Project Name: VILLAGE CENTER

DRB CASE NO/PROJECT NO: 1004676

**CITY OF ALBUQUERQUE, PLANNING DEPARTMENT
INTERNAL MEMORANDUM**

RE: **PROJECT NO. 1004676, Case Number 06DRB – 00746, Village Center, Unser & Night Whisper.**

Sheet
Landscape Plan
L1

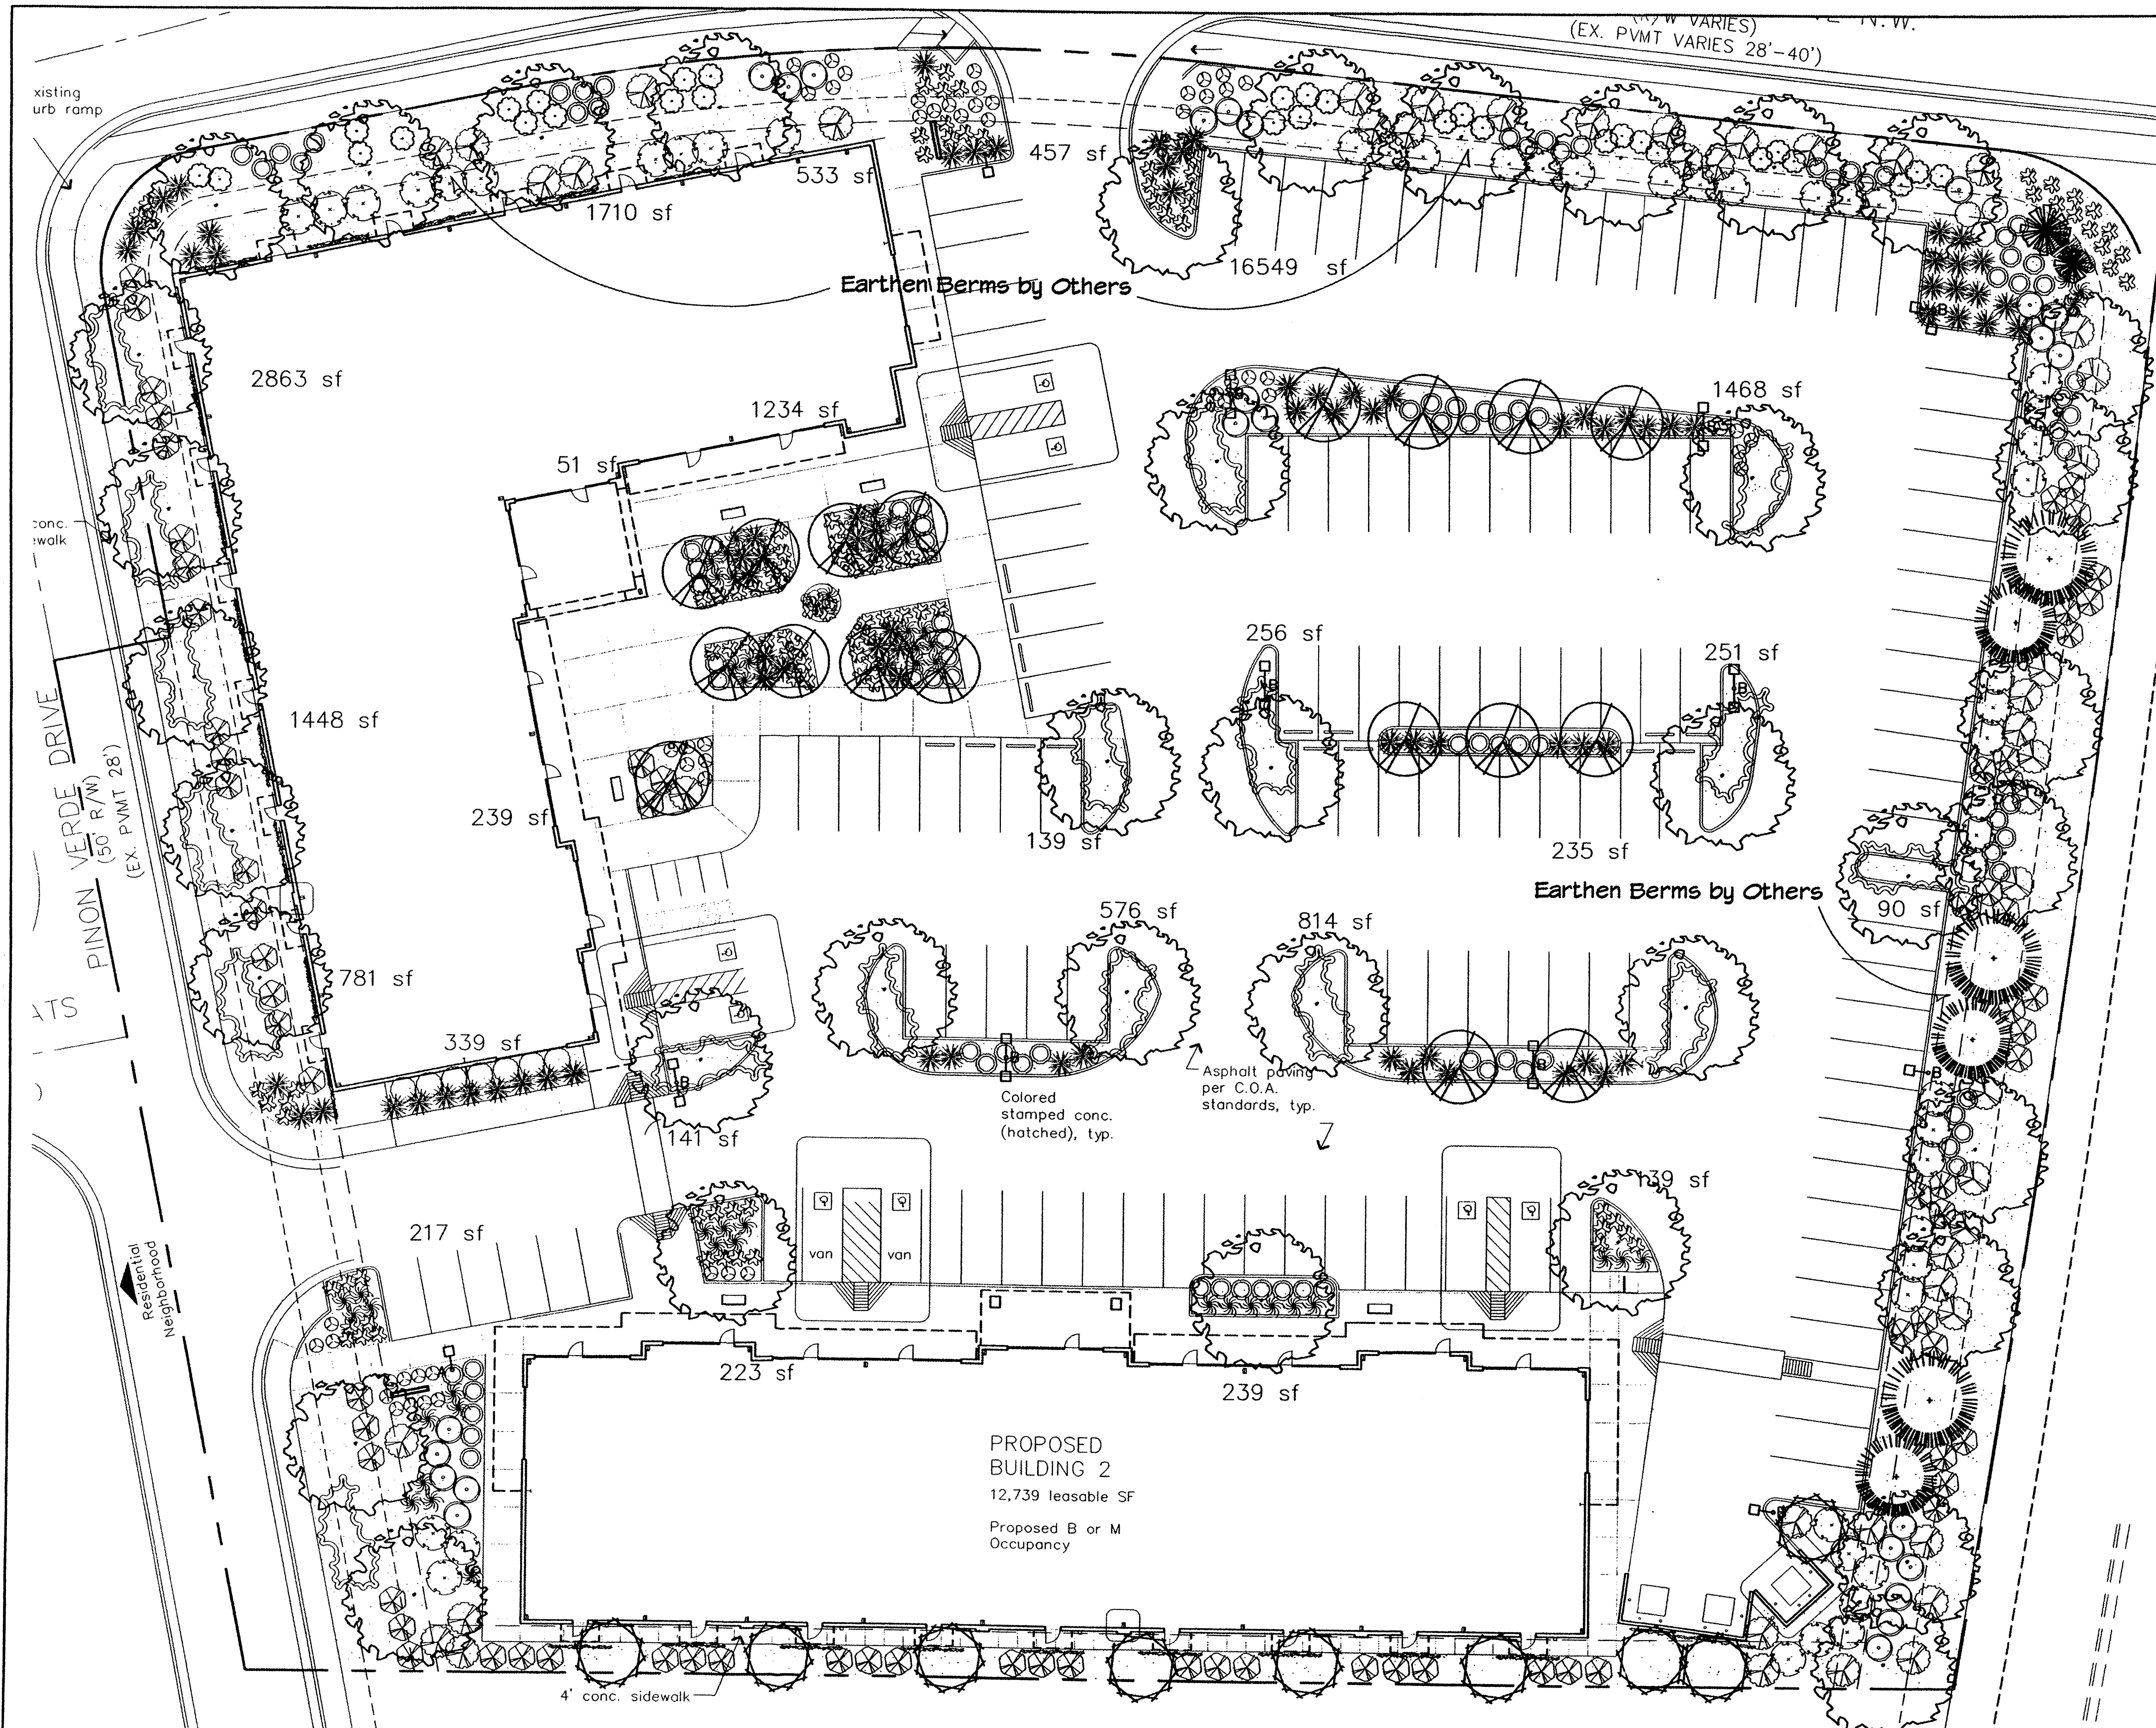
3. Must adhere to either walled or bermed screening
